RMS Ref: SYD18/00594/03

Department Ref: SSD 9275

**MIXED-USE STUDENT ACCOMODATION (SSD 9275)  
80-88 REGENT STREET, REDFERN**

Roads and Maritime has reviewed the submitted application and whilst has no objections to the proposed development, provides the following comments for the Department's consideration in the determination of the application:

8.8m MRV Truck Turning Paths

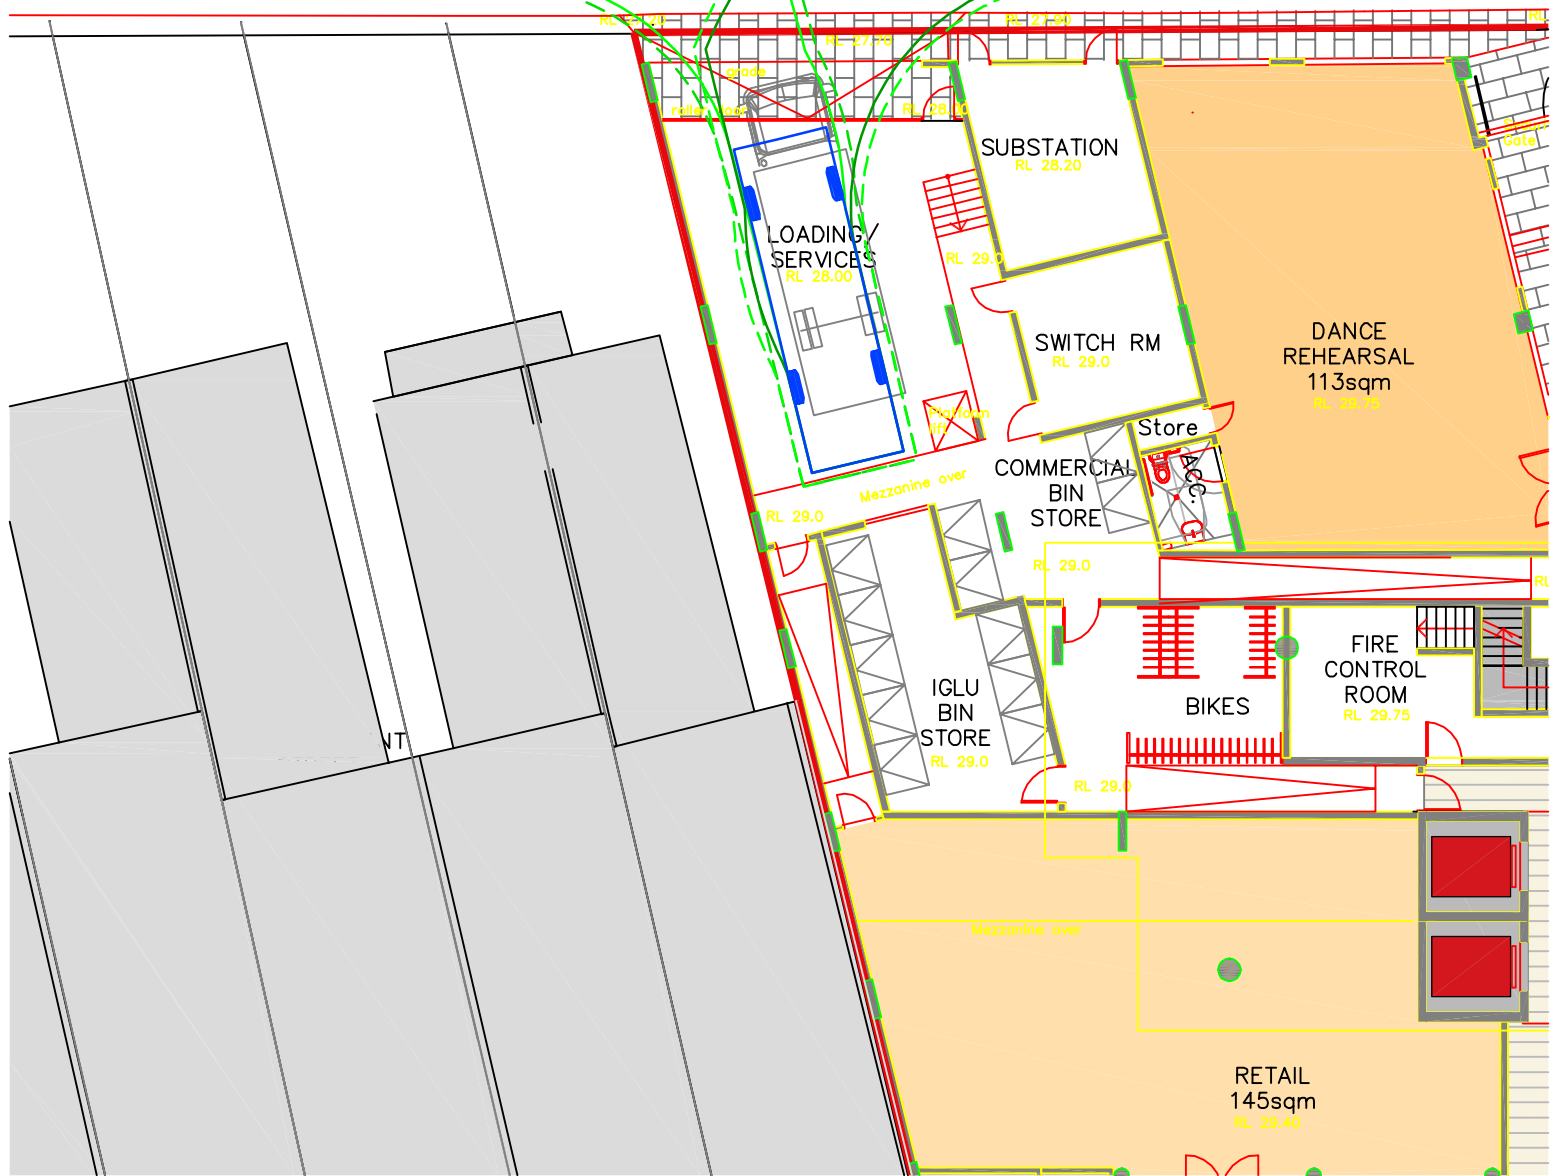
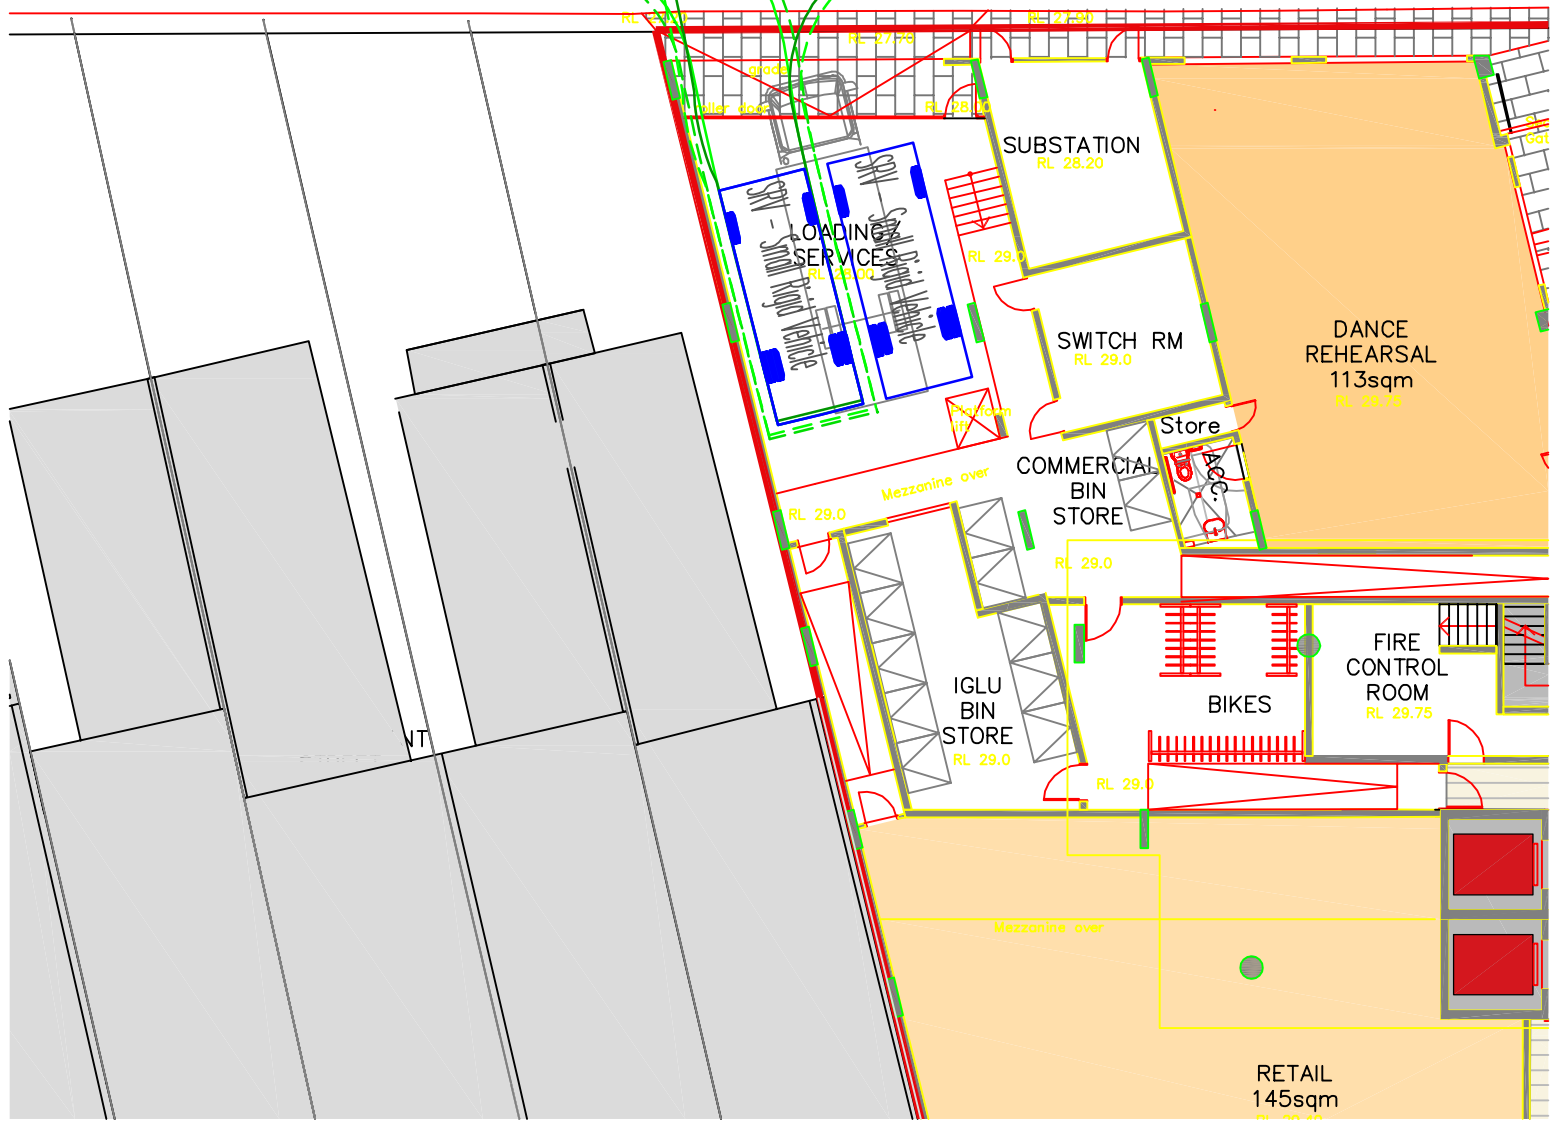
4. All works and signposting (including any utility adjustment/relocation works) shall be at no cost to Roads and Maritime.
5. All vehicles must enter and exit the site in a forward direction.

6. The swept path of the longest vehicle (to service the site) entering and exiting the subject site, as well as manoeuvrability through the site, shall be in accordance with AUSTROADS. In this regard, a plan should be submitted to Council for approval, which shows that the proposed development complies with this requirement.
